Submission to Planning Inspectorate re EDF's DCO for Sizewell C & D.

While Darsham Parish Council (DPC) shares the wider concerns about the impacts of EDF's proposals on transport, environment and tourism with the majority of local Parish Councils, and supports the views of the Environment Agency and national and local conservation groups, our submission concentrates on the siting and impacts of the Northern Park and Ride (NPR) which is located within the Parish Council boundary.

Additional Report – NPR Geology, Drainage & Flood risk

DRAWING TITLE:  
ENVIRONMENT AGENCY  
RISK OF SURFACE WATER FLOODING MAP  
WITH SITE LAYOUT

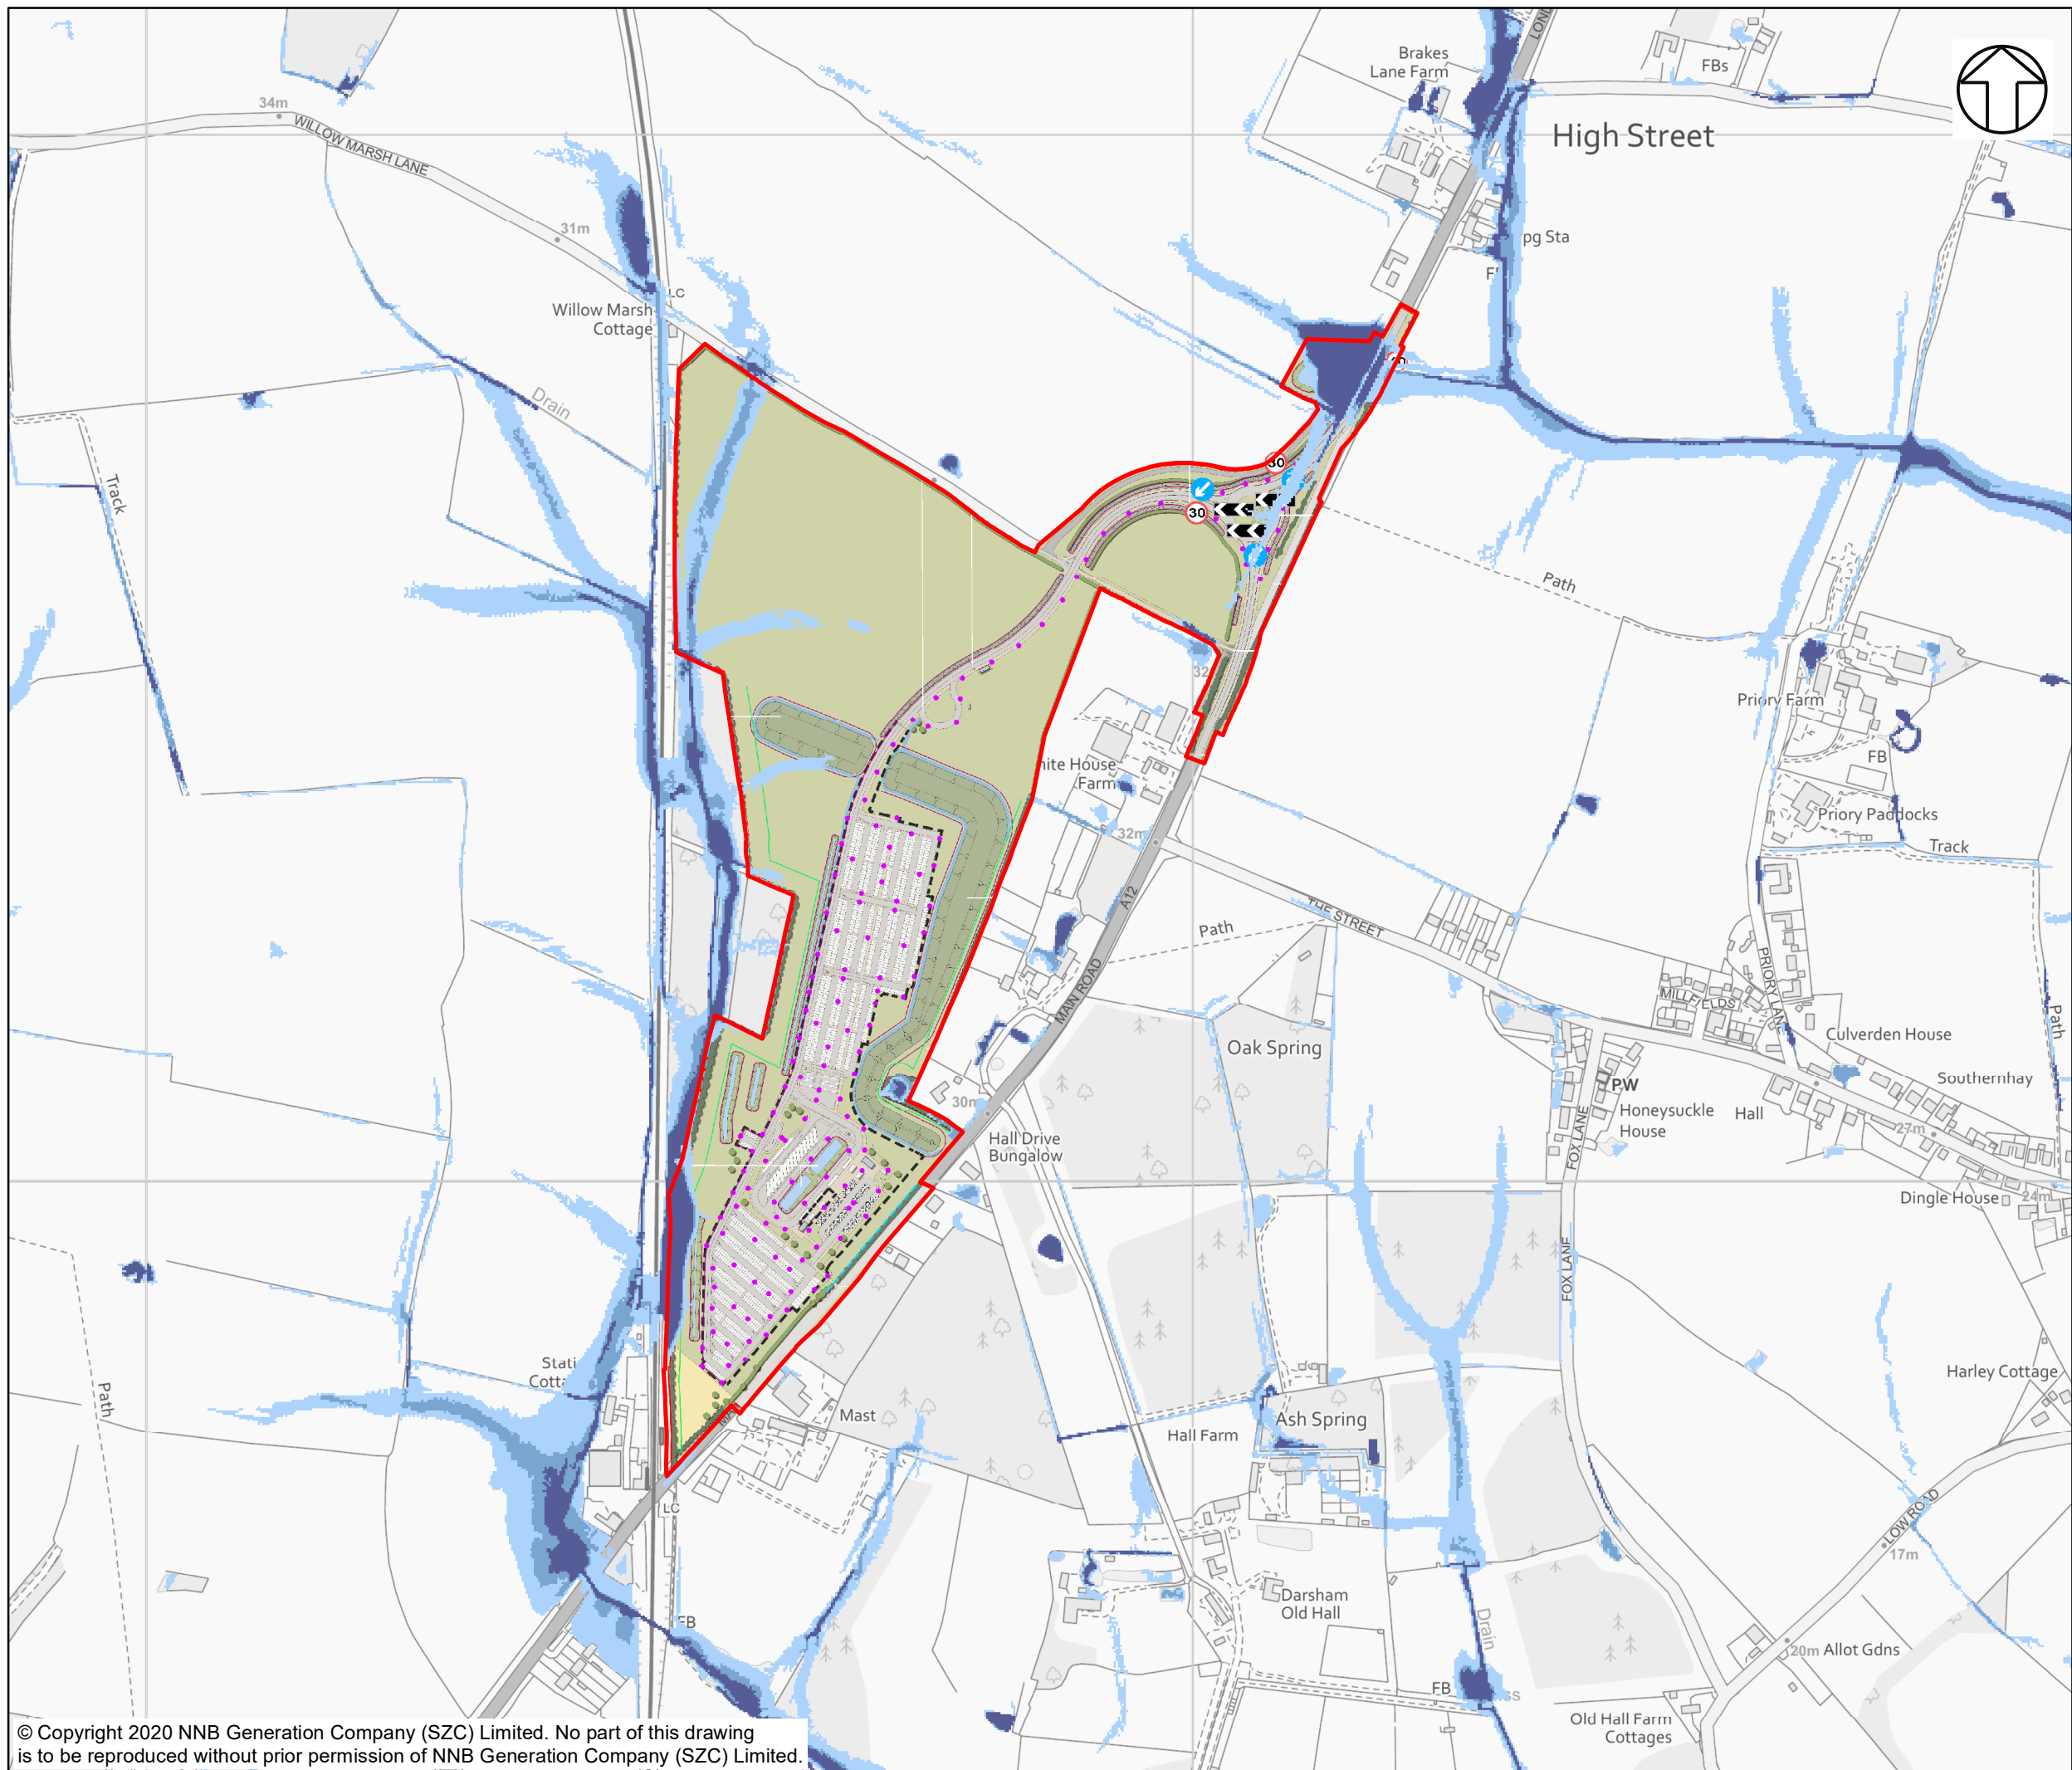
New research information has revealed that there could be drainage and flood risk problems associated with the NPR. EDF have proposed a storage basin with overflow to existing watercourses running under the railway. The underlying geology prevents natural drainage within the site and is likely to lead to existing water courses being overwhelmed in heavy rain.

I have highlighted the disparity with the details in the document referred to earlier. In my view the FRA is fundamentally flawed by this erroneous statement and this has led to a design that is inappropriate.

Despite the very obvious limitations on the ground's ability to drain surface water down to underlying more permeable ground the erroneous FRA statement has led EDF to propose the extensive car park and roads will have surface water draining into a pit dug on the site, referred to as infiltration basin on the plans - see below for where the plan is*) which is meant to allow the water to soak away into the natural ground. They have also incorporated open U or V shaped trenches called swales also designed to act as a soakaway feature. As all the features are in low permeability soils. In all probability this design will not be able to cope with the rapid flows of water into it from the car park and roads when a major storm occurs.

The site falls in level towards the railway and from the plans there is an agricultural ditch that current collects any rainfall runoff which drains under the railway north of the station (see the thick blue lines on the plan - green where it passes under the railway in a brick culvert). Any overflow from the car park drainage features will naturally go to that existing feature. The ditch is, I suspect, not capable of accepting any significant increase in flows and there is no detail on the culvert. It may be the culvert that restricts the ability of the existing ditch to take more flow. If not, then the capacity of the culvert under the A12 south of the station may be critical - an area with historical flood issues - see page 16 of the Flood Risk Assessment for the Northern Park and Ride

Nothing like backing two horses. In the set of Not for Approval plans in **Book 2 Plans, Volume 6 Northern Park and Ride page 4 of 25** you will see very thin blue lines connecting many of the swales and the infiltration basin to the existing agricultural drain/ minor watercourse with the words on the plan 'Outfall to Existing Ditch'. Naughty; why are these details not in the Plans for Approval? From reading the FRA I suspect EDF have not assessed the ability of the existing ditch/culverts to cope with any additional flows as the flaw in the earlier quote above from paragraph 5.5.2 made EDF only see that as a very low probability requirement and only requiring a limited flow into the ditch.
